Consultation Response from: KC Environmental Health (Pollution & Noise Control)
2021/93305 - 61-65 New Street, Huddersfield, HD1 2BQ
Change of use and conversion of existing buildings, erection of split-level seven storey extension comprising four-storey stairwell, five-storey roof-top tower block and enclosed courtyard to form 31 dwellings and sub-division of the retail unit forming 61-63 New Street (Listed Building within a Conservation Area)
**Date Responded:
21 January 2022**
**Responding Officers:
Mohammed Nasim
Natalie Heaney**
**Responding Ref:
WK/202140124**

Figure 1.0 – Indicative Site Layout

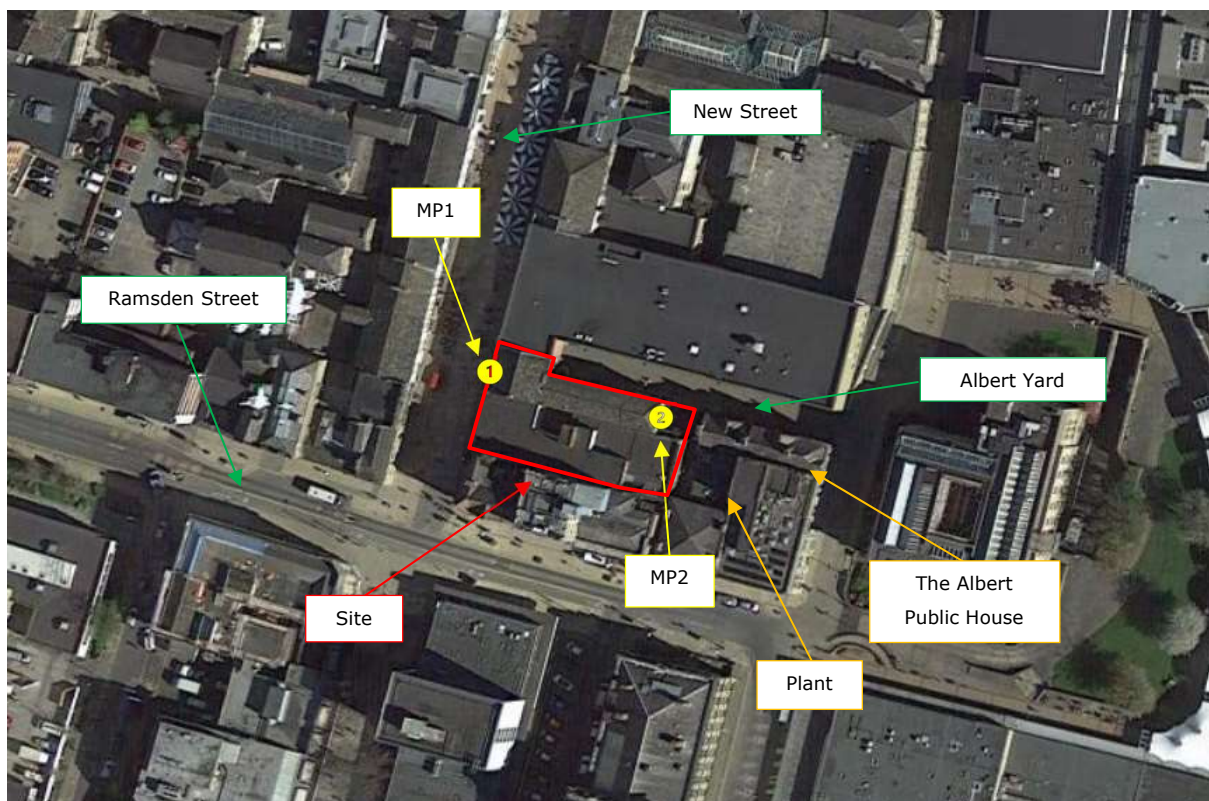
An environmental sound survey was carried out from 17 December 2021 to 20 December 2021 and the measurement positions (MP) are shown in figure 1. MP1 is to the front of the property and MP2 is at the rear. These monitoring positions were chosen in order to collect representative sound levels at the proposed development during the daytime and night-time periods. The report states the area surrounding the site is primarily commercial in nature with a minority of residential dwellings. The noise profile is typical for this type of area and is dominated by road traffic noise emissions from surrounding roads and footfall from pedestrians and patrons of the local retail units and public houses. Plant units are located to the rear of site which service the neighbouring public house (The Albert). The rear of site also overlooks a smoking shelter and beer garden for The Albert. Buses frequently pass by the property to the south.

Figure 2.0 – Façade Colour Grouping

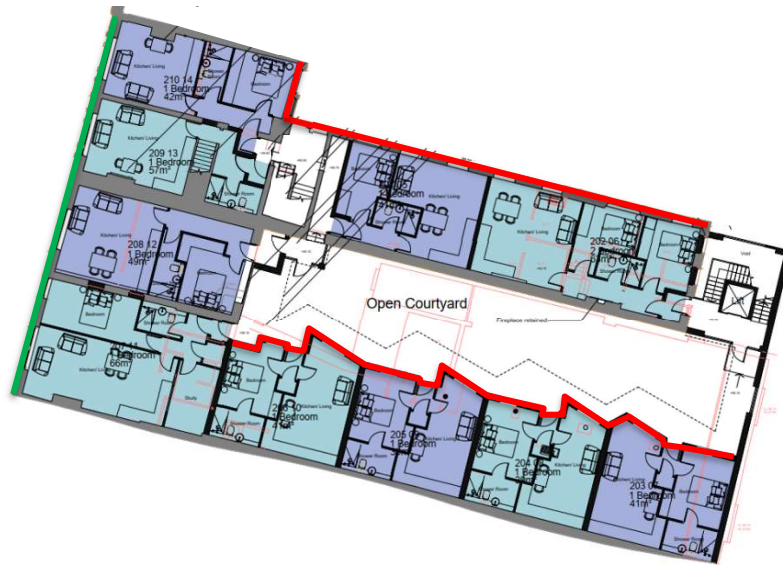
The report states that the measured sound levels at the façades of the property vary significantly and in order to correctly specify the required sound reduction, the façades have been divided into two colour groups: red and green. Appropriate models of glazing and ventilation for each façade colour are shown in Tables 4 to 8. Secondary glazing and double-glazing options have been given for the red façades as it is thought the new extension to the building is likely to have double-glazing installed. Based upon a partially open window, the calculations show that the internal noise levels are predicted to be significantly above the criteria, and as such, the report recommends that secondary ventilation is also employed and a through wall system is recommended.
